Re: Minor Modifications to Re-Build Single Storey Extension.

At: Plot 1, "The Old Smithy", 64 Hoyland Road, Hoyland Common, Barnsley.

Approval No: 2008 / 0653. Approval Date: 12th. June 2009.

Project: Plots 1 & 2 Conversions
Client: Mr. & Mrs. A. Turner
Title: Property as Proposed
Address: Land adj. "The Old Smithy", Heyland Rd, Heyland Common
Drawn by: 999
Scale: 1:100
Date: 08/08
Rev: 670-08
Member of the Chartered Institute of Architectural Technologists

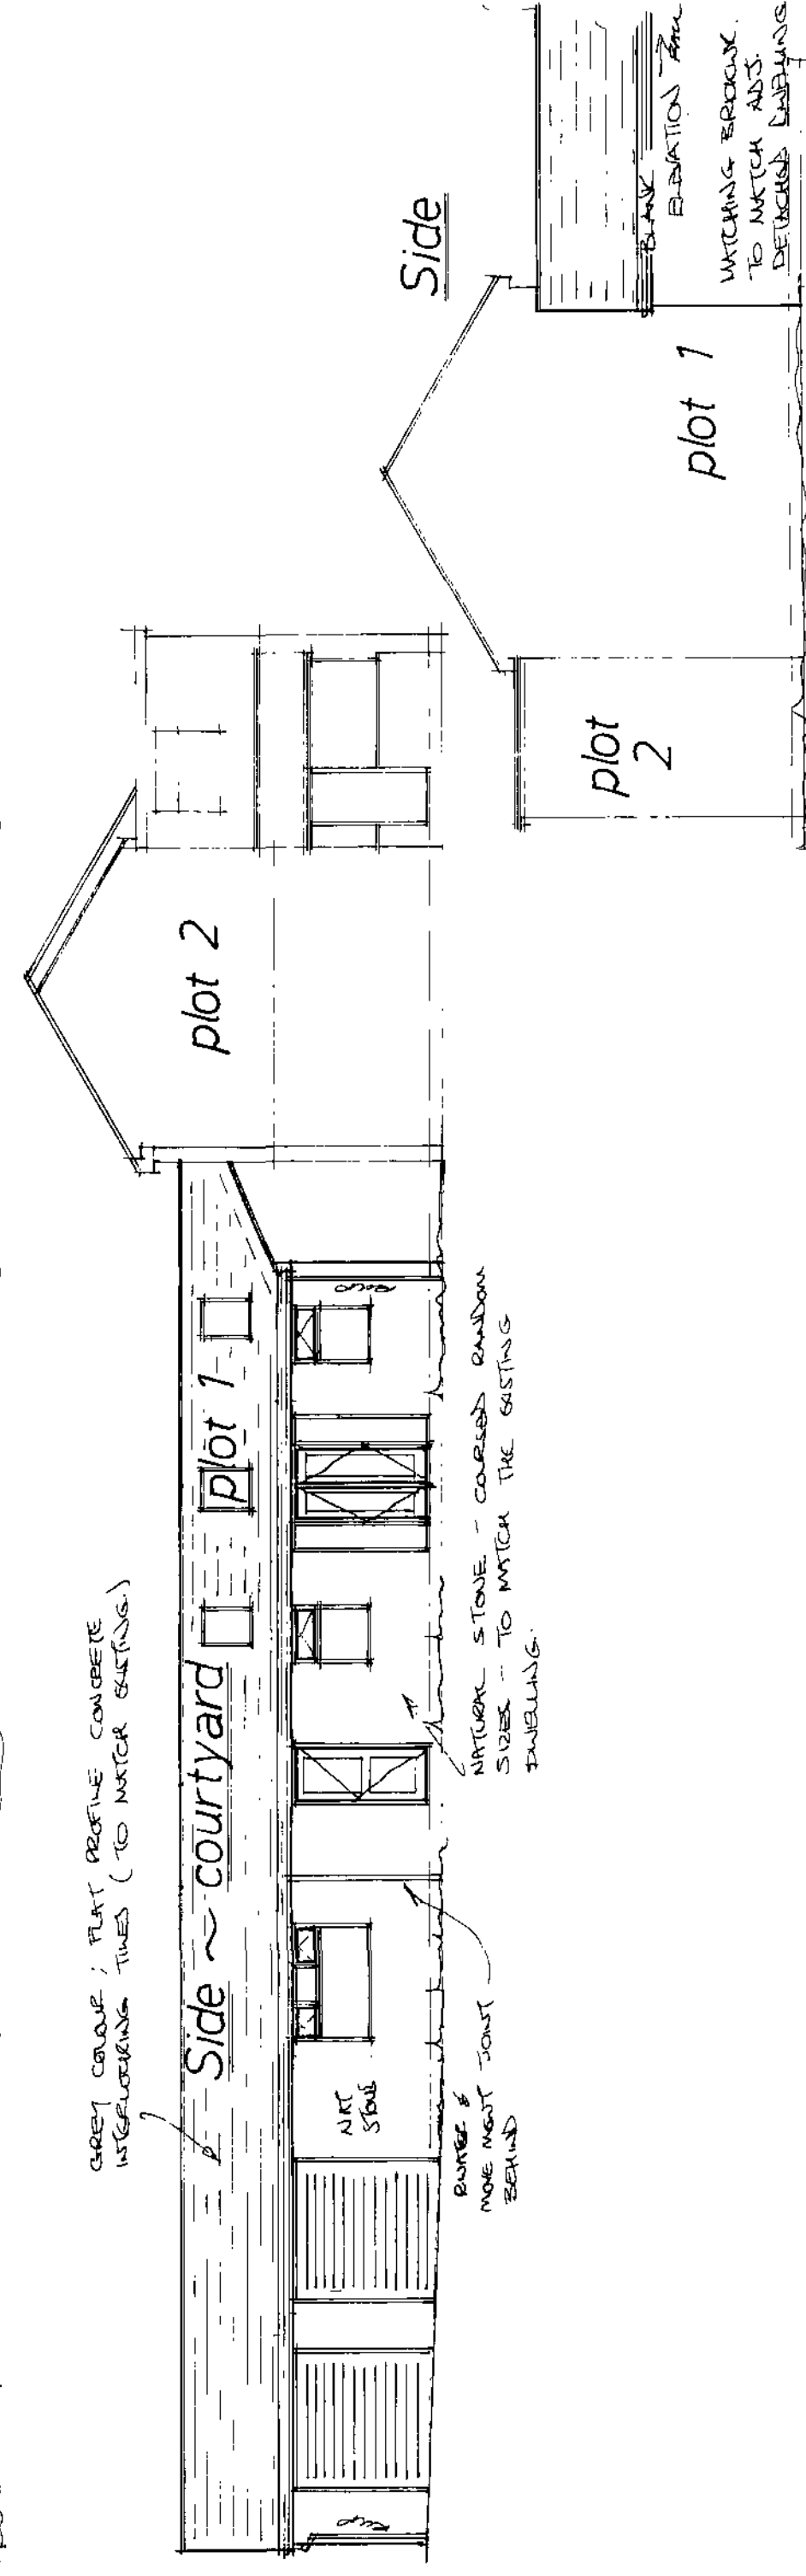
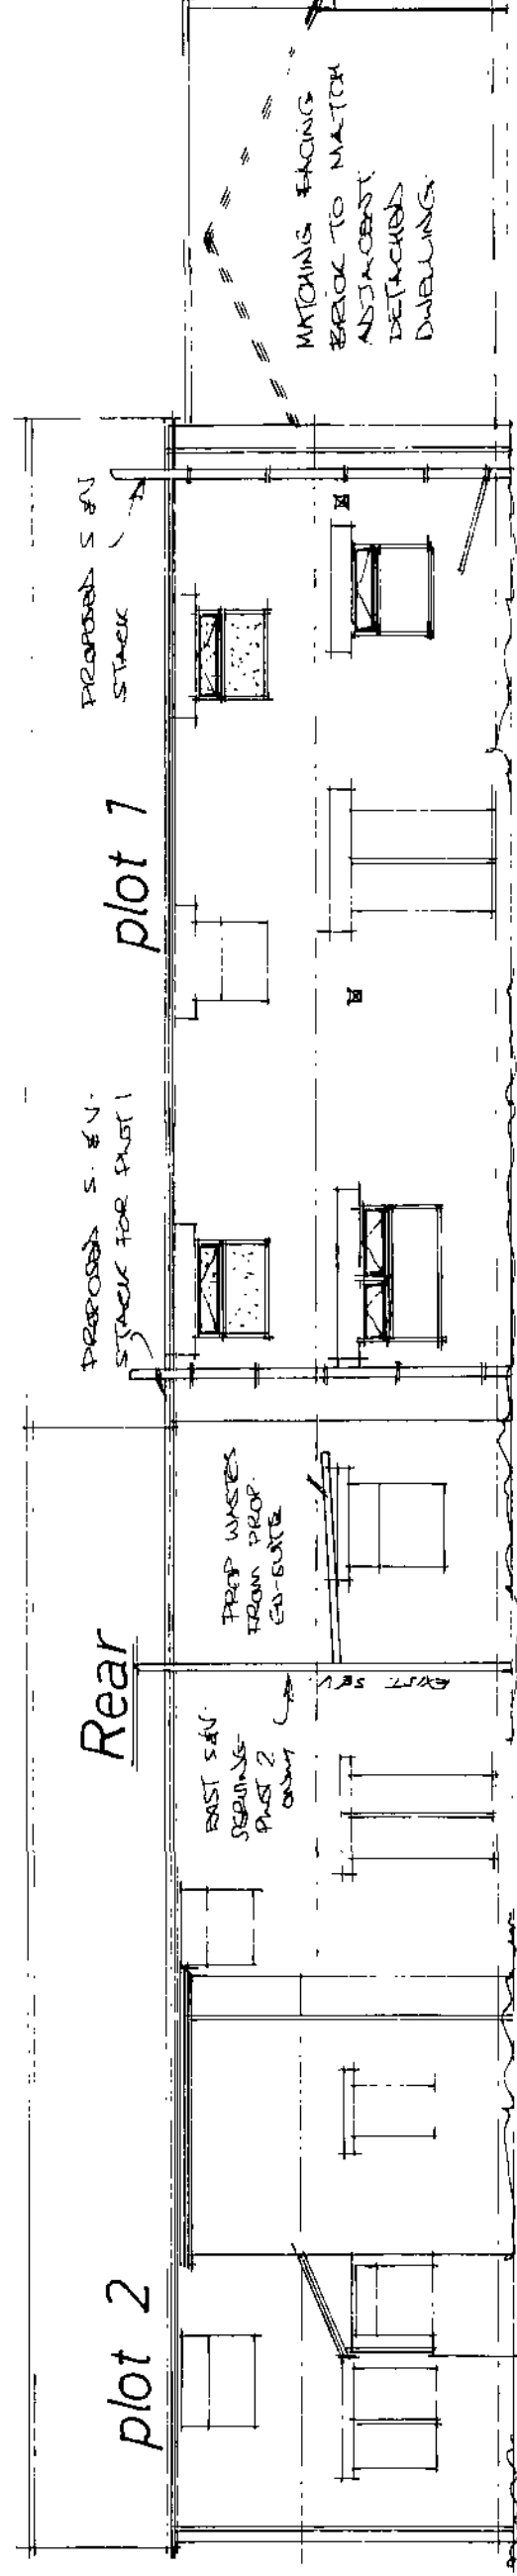
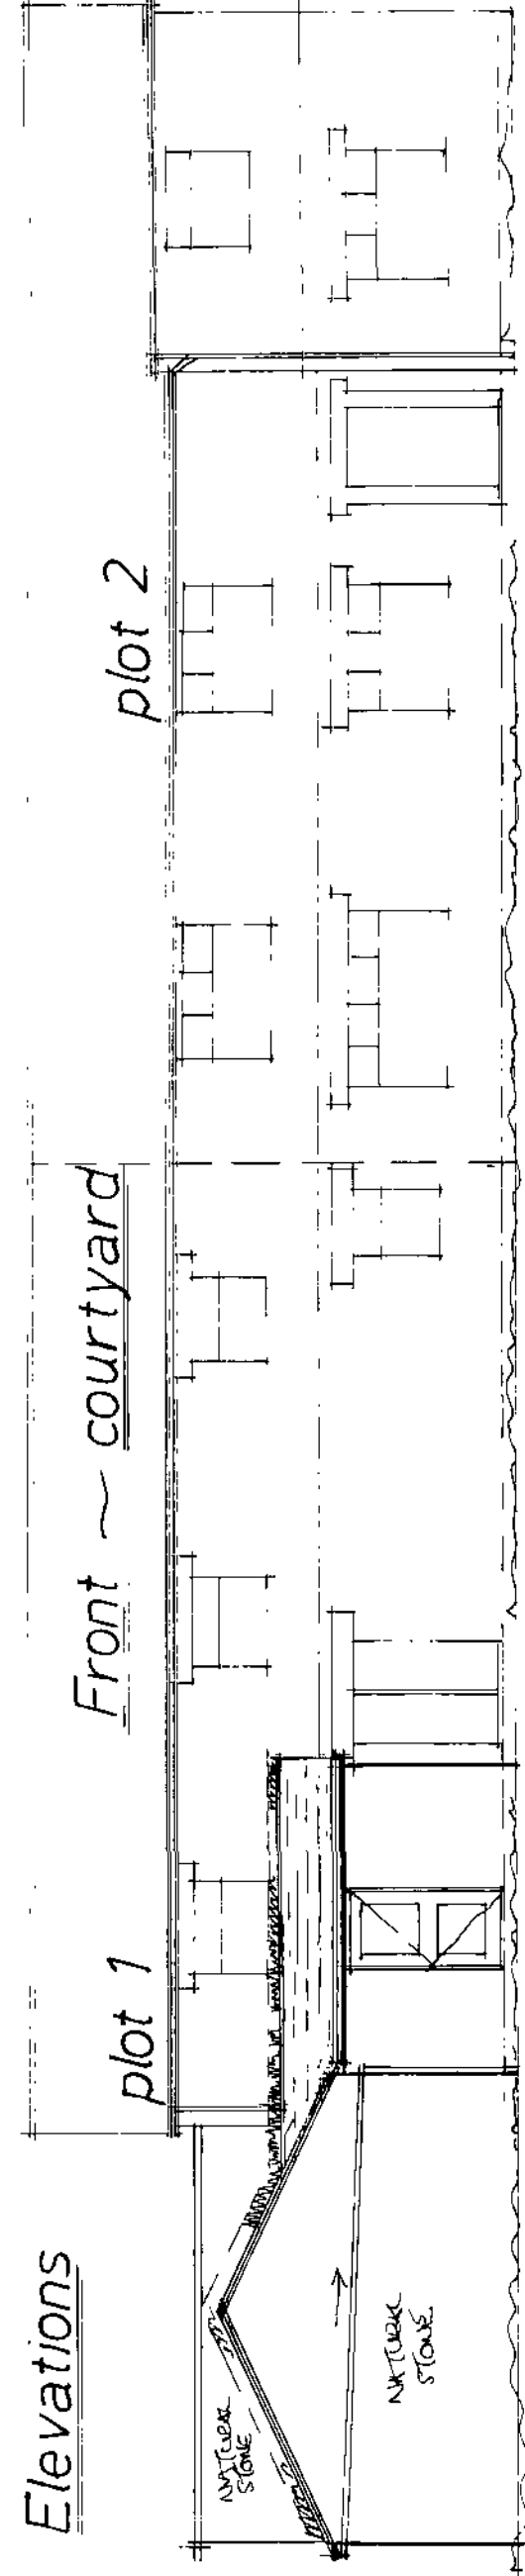
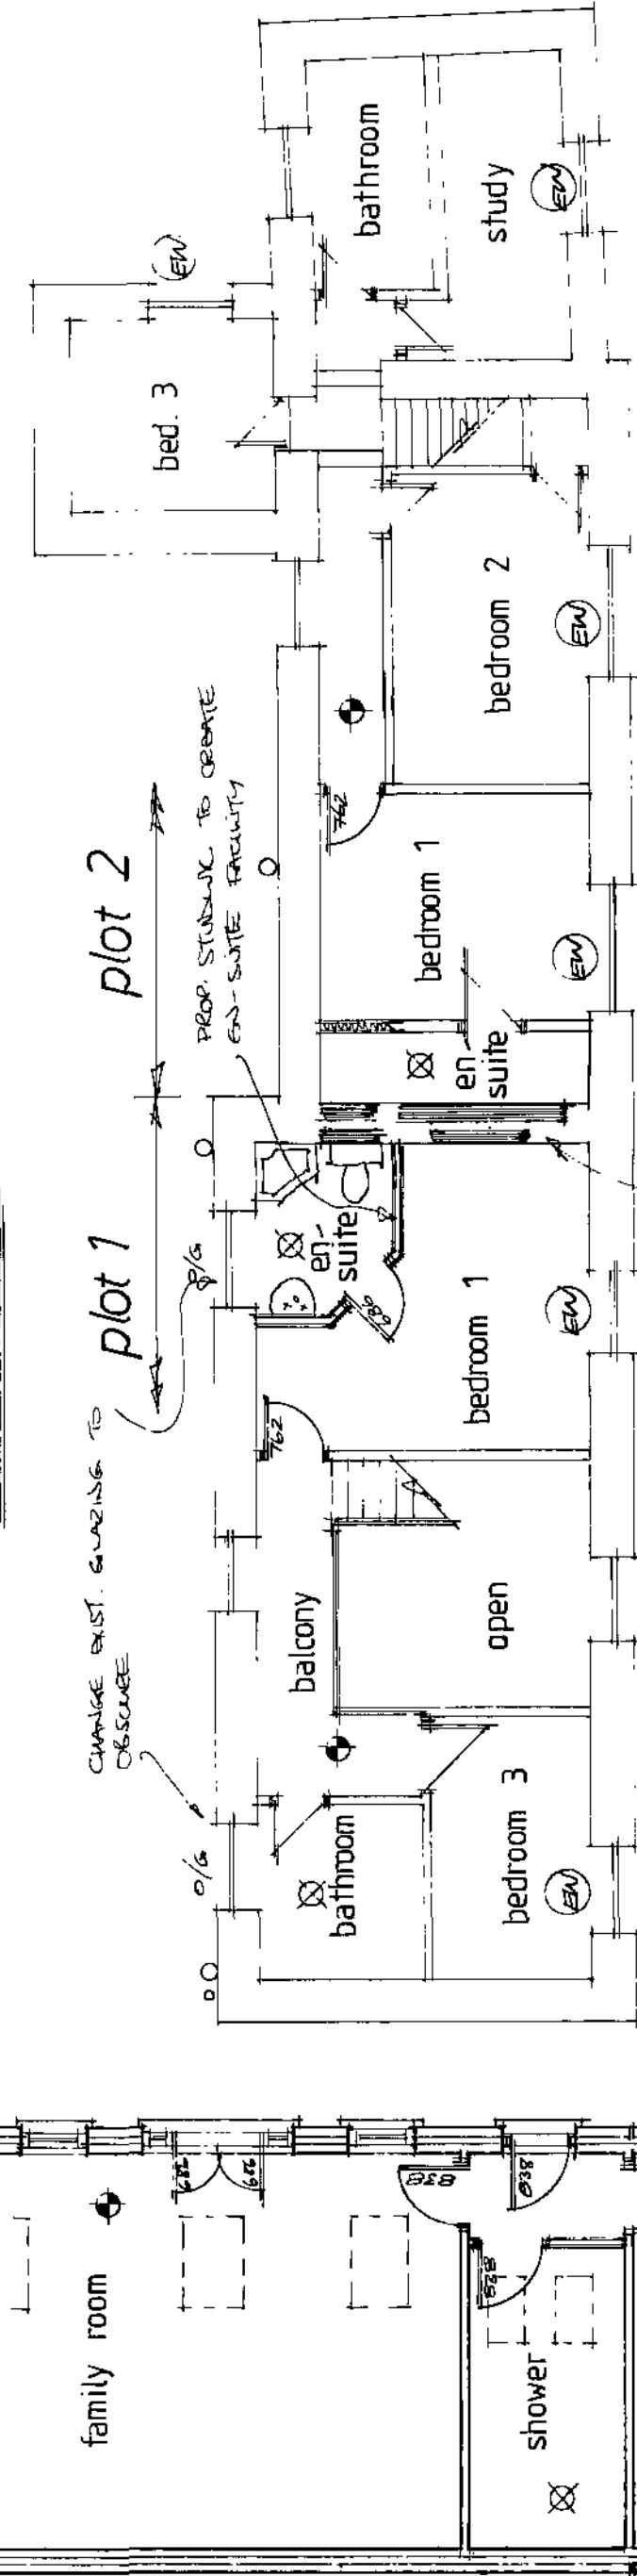
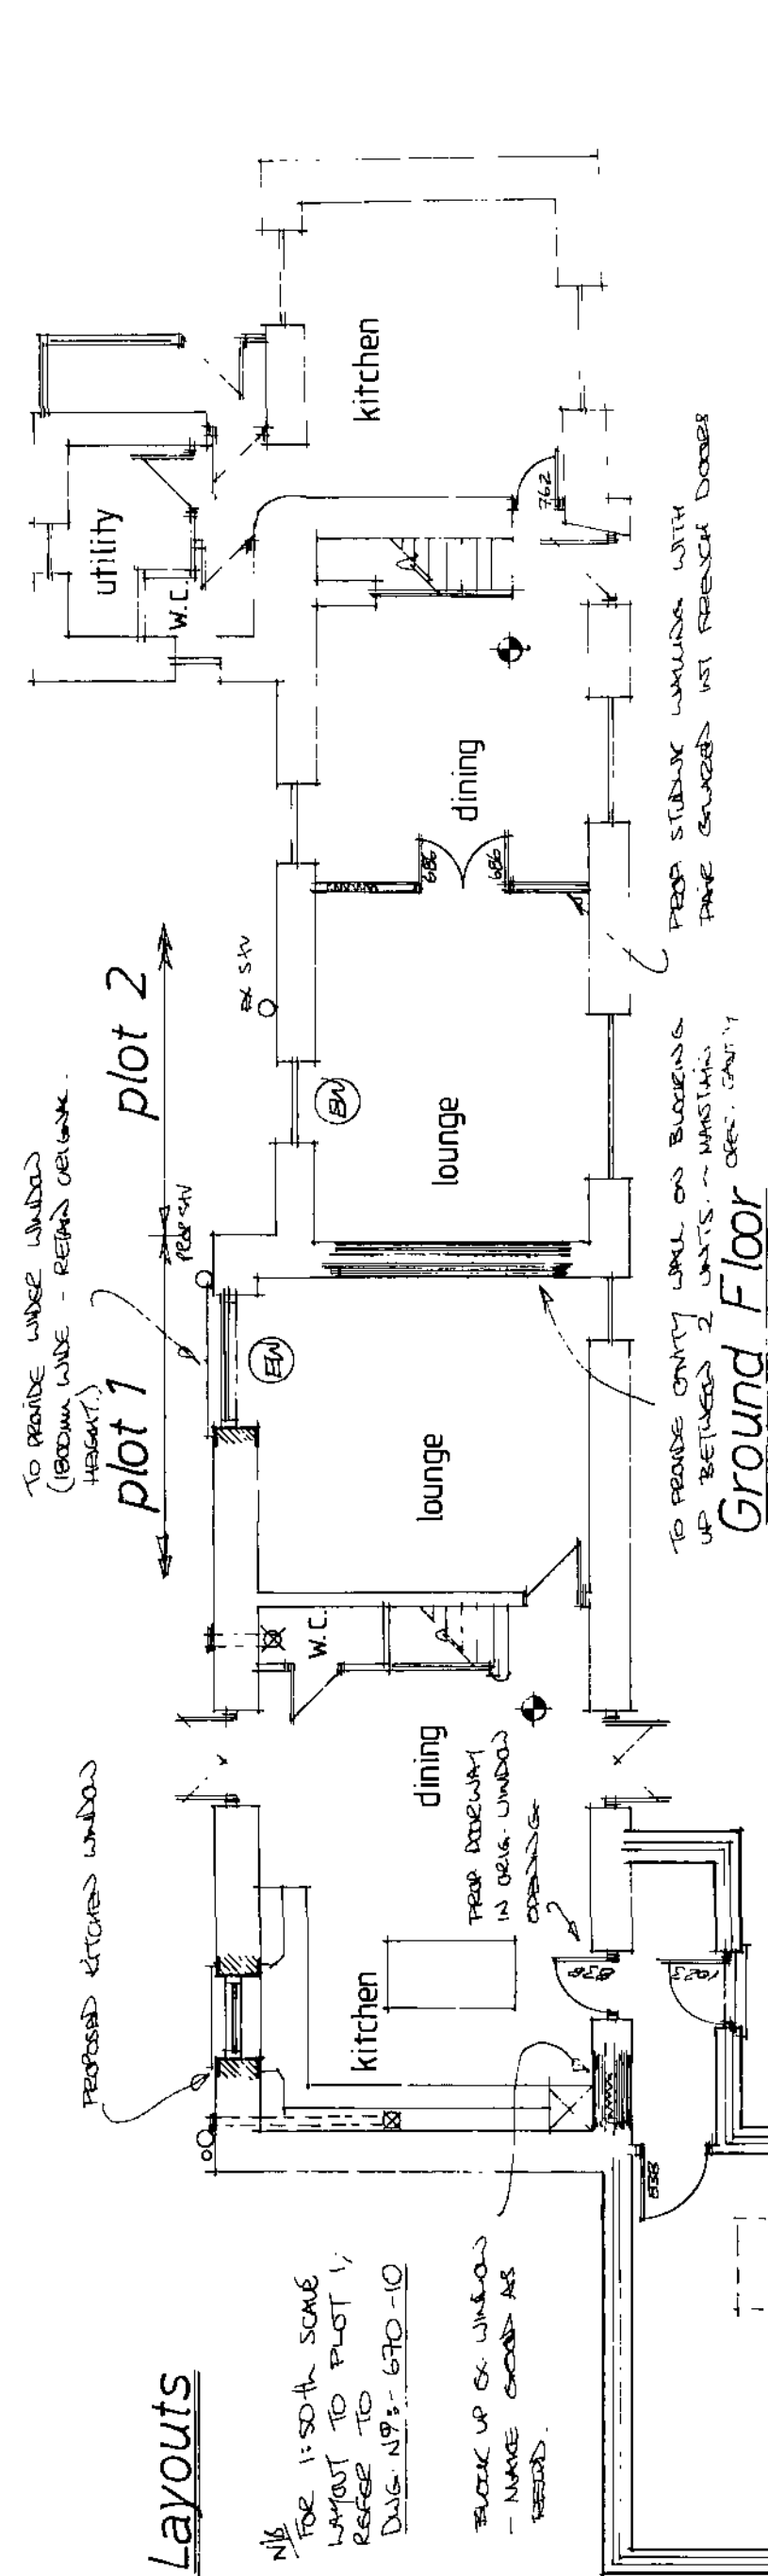
The alterations simply relate to the change of materials on the rear and rear / side elevations of the proposed single storey re-build portion on Plot 1 only.

The original materials approval was for render on blockwork, however the adjacent neighbours have complained based on the grounds that only they will be able to see both of these elevations referred to and therefore would prefer brickwork to match there property. Sample of the brick required is attached. Take note that also by altering to brickwork, this will alleviate the maintenance problems on this unseen boundary.
